**From:** Bloomer, David <David.Bloomer@lancashire.gov.uk>  
**Sent:** 13 July 2015 08:55  
**To:** Stephen Kilmartin  
**Cc:** LHS Customer Service; planning  
**Subject:** app3/2015/0515 Church Raike Chipping

Ground Floor

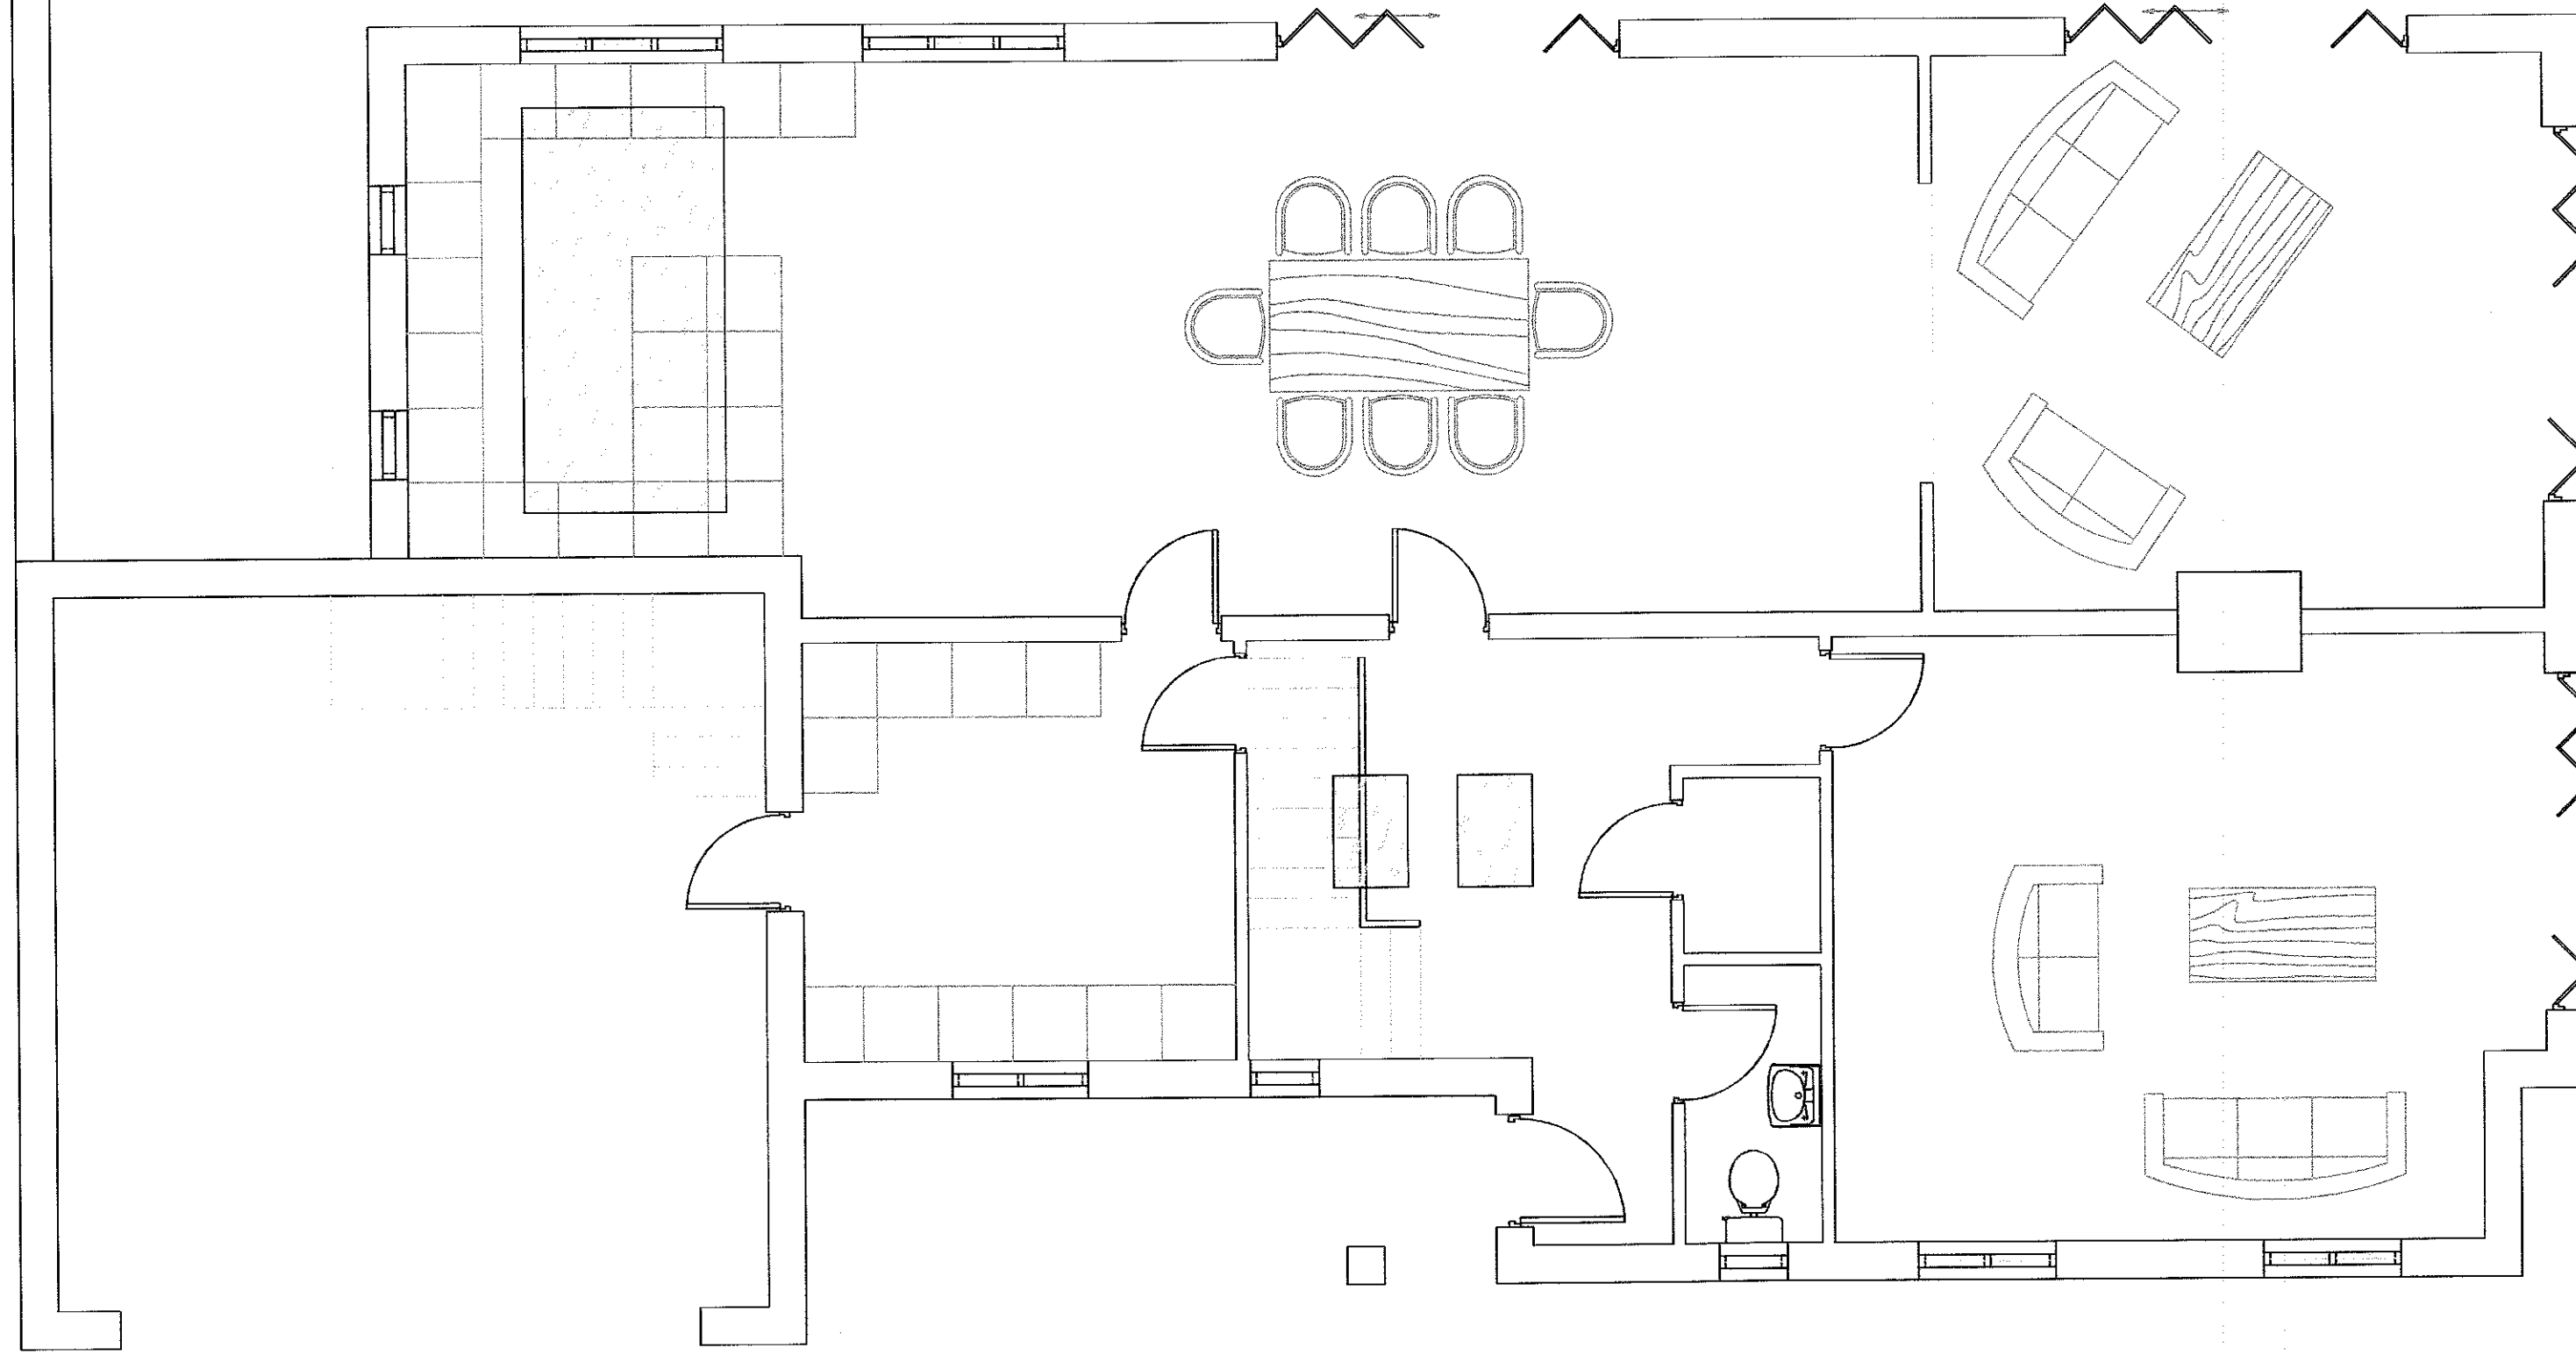
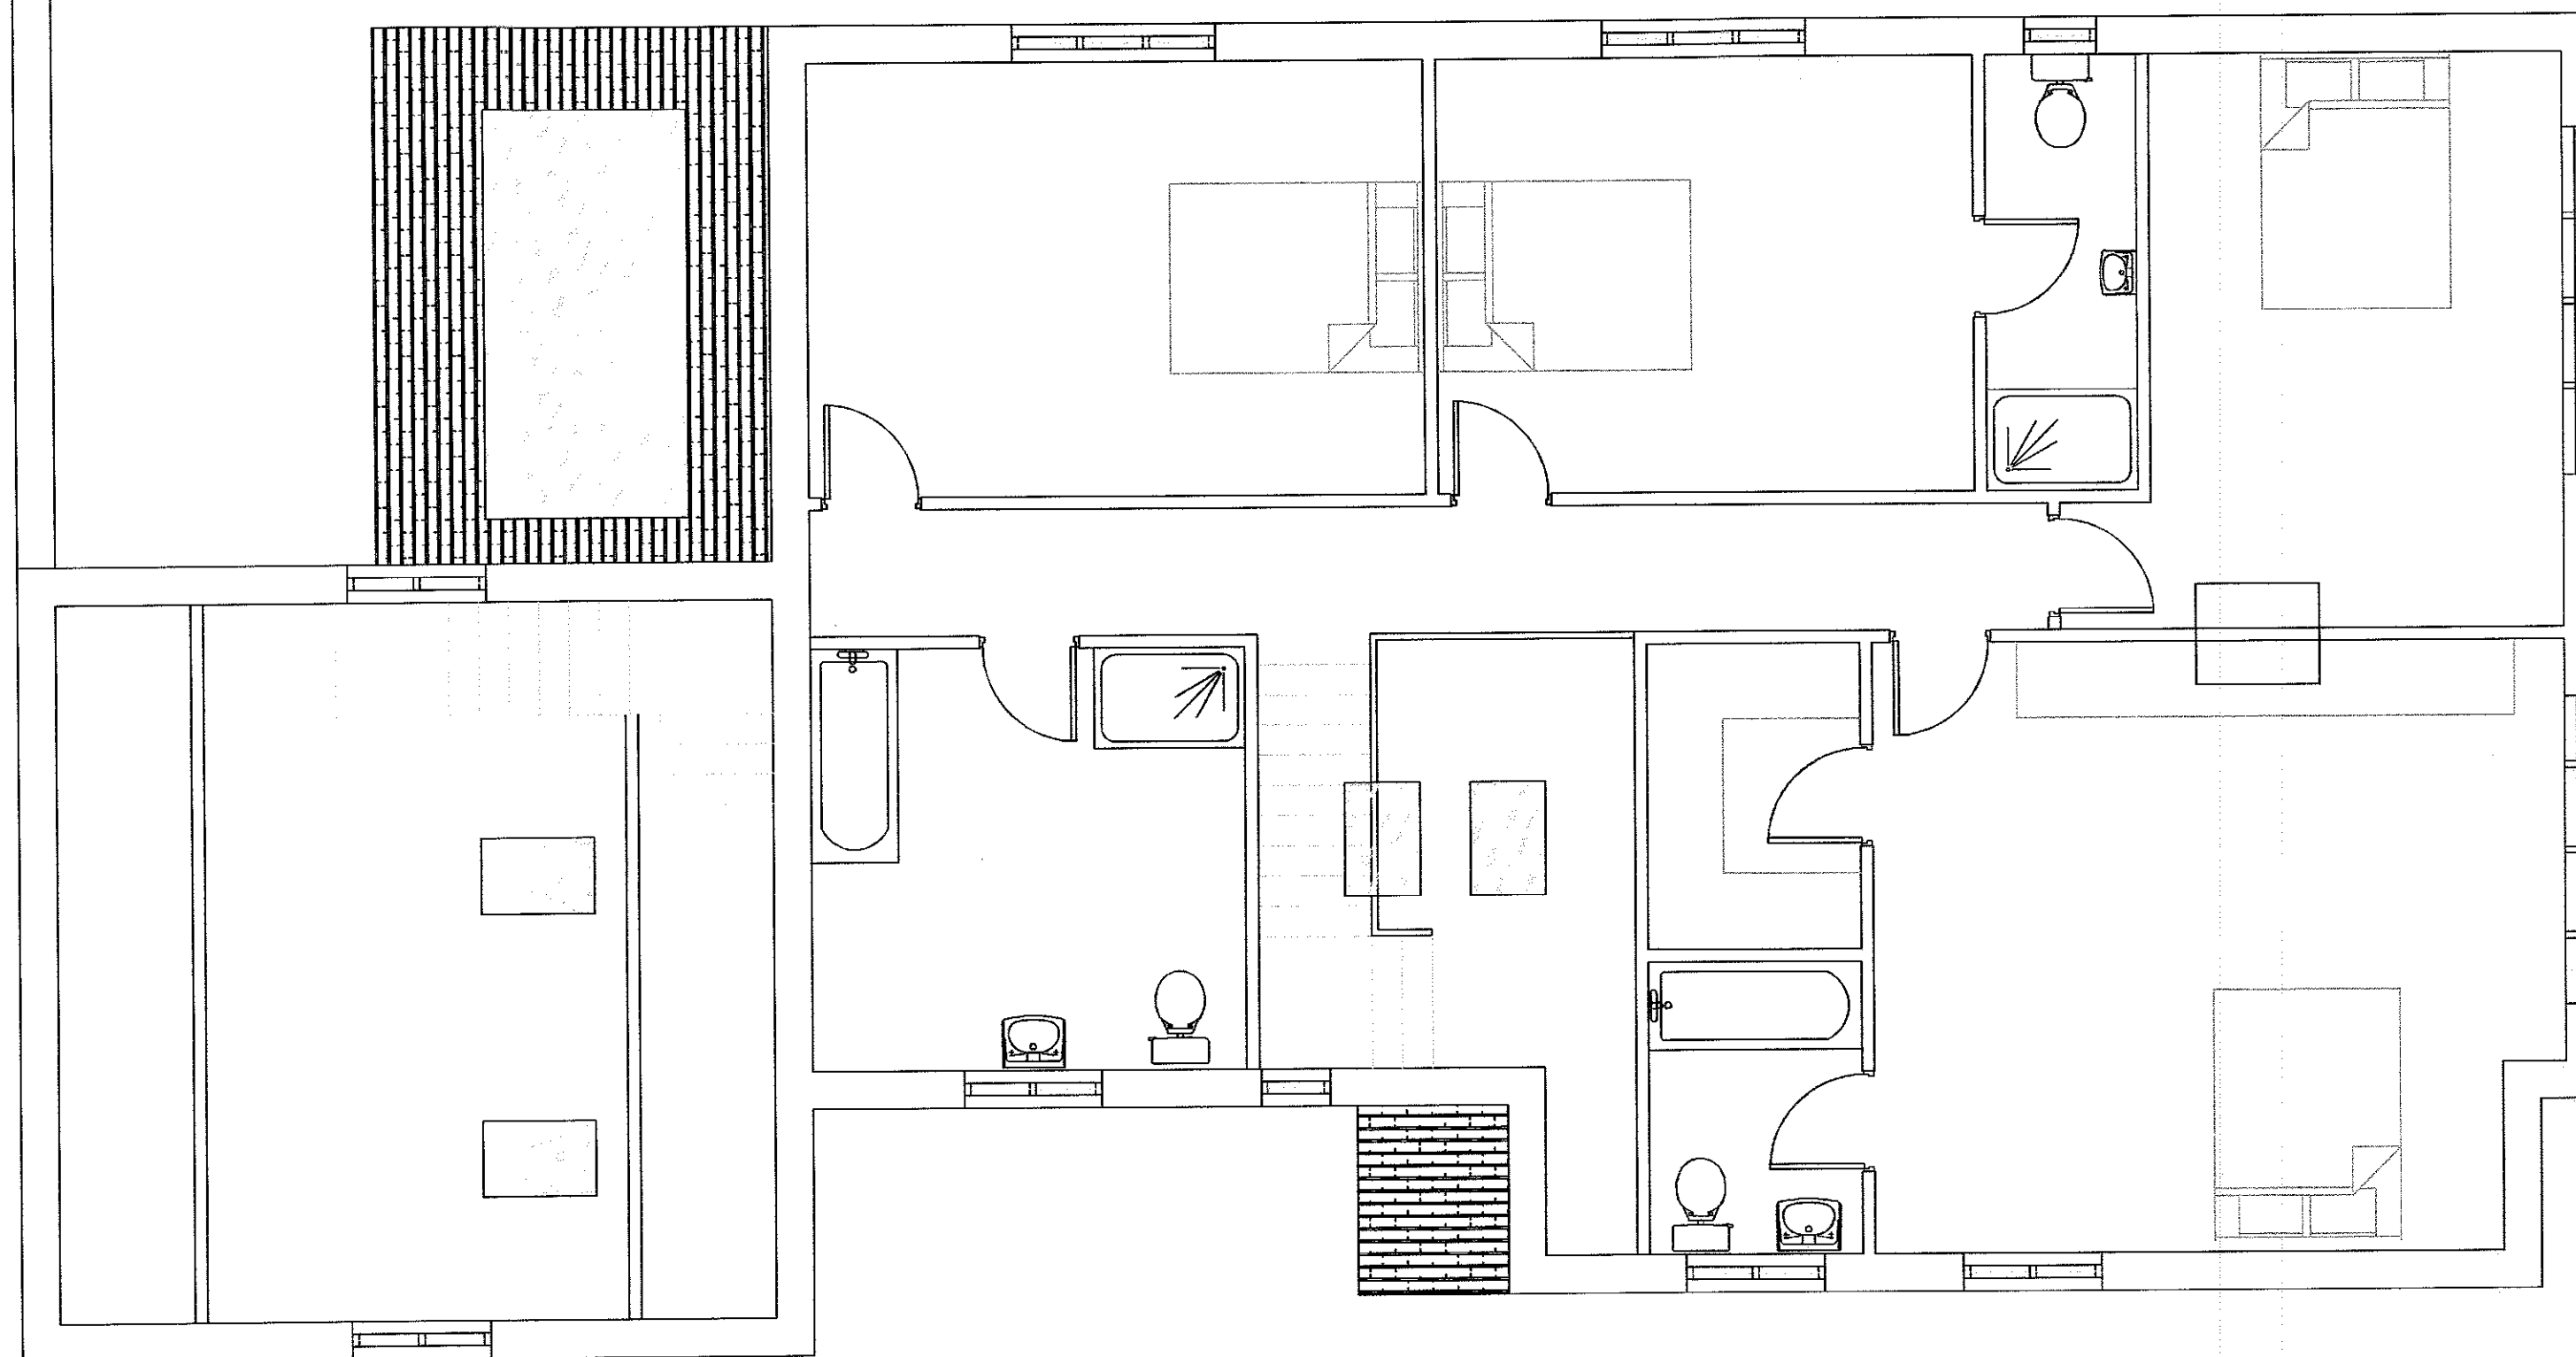
Whilst I would raise no objection to the proposal in principle the parking provision shown on the site layout plan( in front of the garage) needs further consideration. The minimum dimension for a parking space and reversing area is 11 metres. The plan shows less than 9 metres which would result in excessive manoeuvring at the site access to the detriment of the other properties served by this shared access.

There is ample space elsewhere within the site to accommodate an additional 2 parking spaces and subject to the submission of an acceptable parking provision I would raise no objection to the proposal on highway grounds. In addition, I note that there is no height given for the stone wall adjacent to the entrance. The revised parking plan should also provide details of the height of this wall. Anything greater than 1.05m would not be acceptable.
